**KIRKLEES METROPOLITAN COUNCIL
INVESTMENT & REGENERATION SERVICE**

Reference No: 2021/62/90060/W

Site Address: adj, 9, Station Road, Marsden, Huddersfield, HD7 6BS

Description: Formation of retail unit for the sale of sandwiches and bakery goods (within a Conservation Area)

Proposed front elevation (1:100)

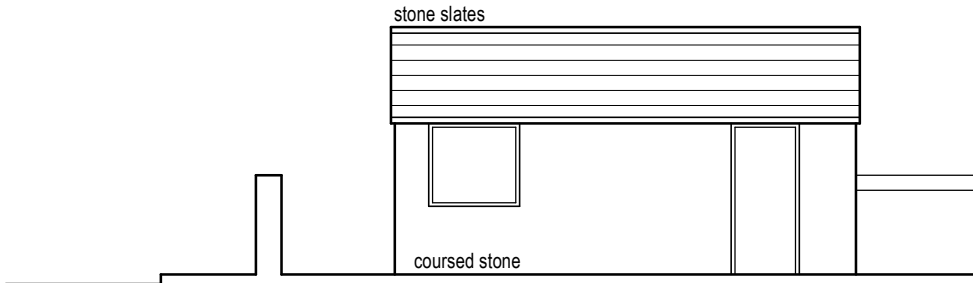
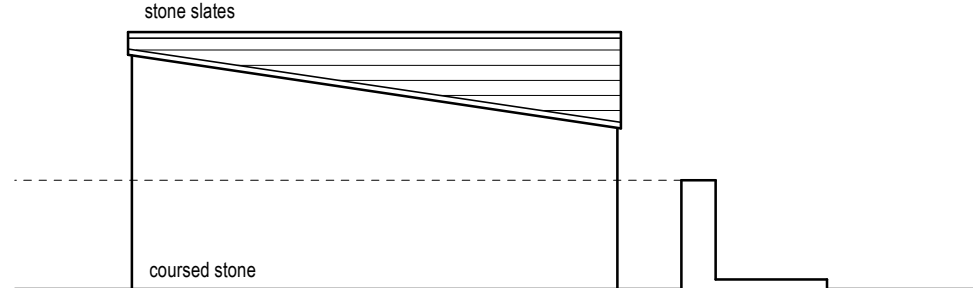
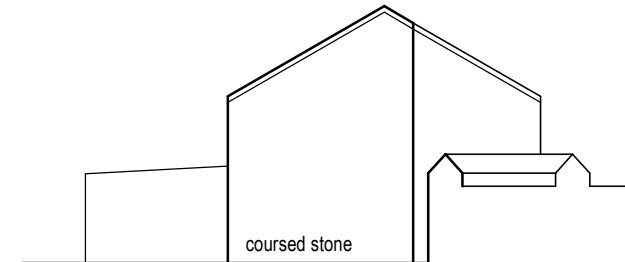
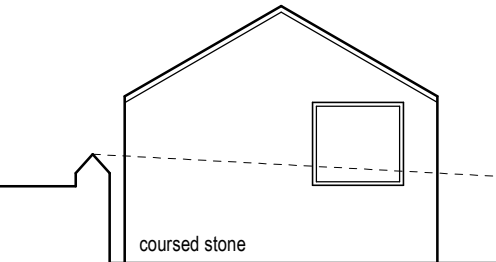
In this case, initial concerns were raised regarding the design and materials proposed for the new building. As initially proposed the building was of a flat roof design and a mix of timber cladding and stone. As such, amendments have been sought to demonstrate a simple dual pitched structure which will be constructed from natural stone with a slate tiled roof. This type of development would be in keeping with the neighbouring built form and therefore is considered to be in keeping with the environment.

3. The building hereby approved shall be constructed from coursed stone with a stone slate tiled roof. The development shall thereafter be retained with this material and finish.

Proposed site plan (1:100)

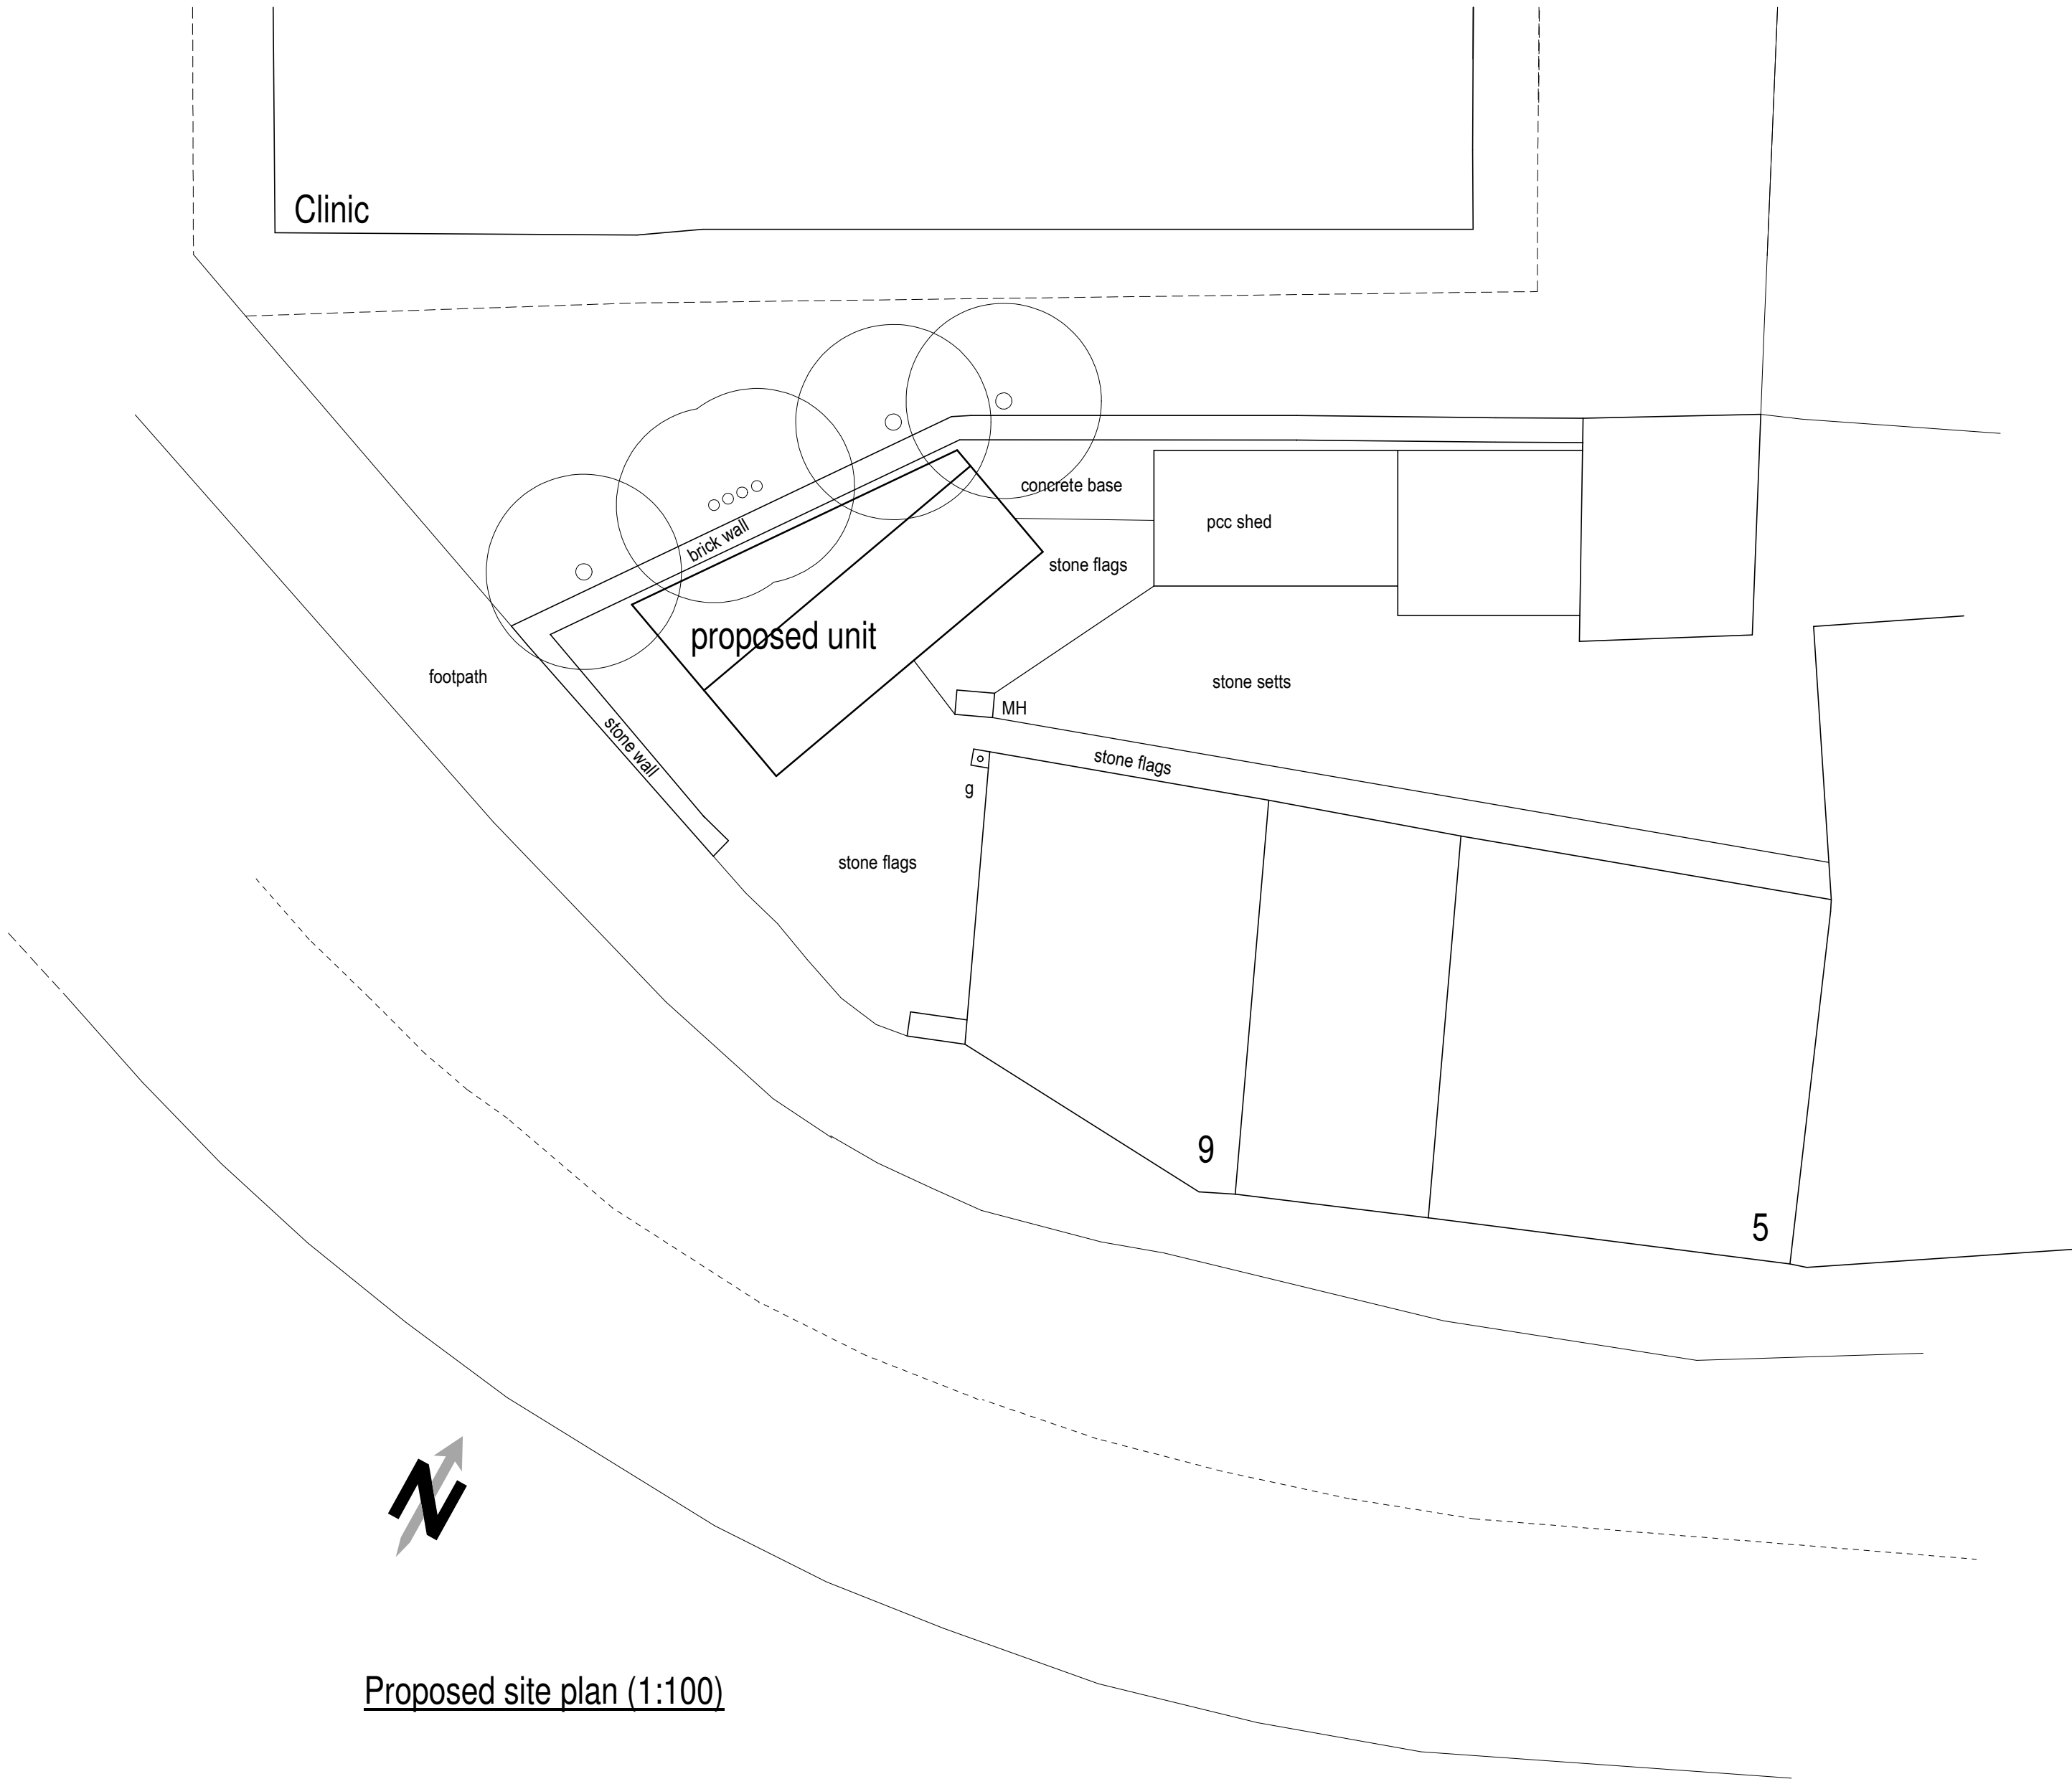
In terms of the size and scale of the new building, this would be approximately 6.5m in depth, by 4.1m in width, with an overall height of 3.4m. The submitted plans show the development to sit comfortably within the site, which would not result in its overdevelopment. The existing dry stone wall along the sites frontage would also be retained as part of this proposal, which is considered to be a beneficial element of the scheme given boundary treatments can form important features within conservation areas.
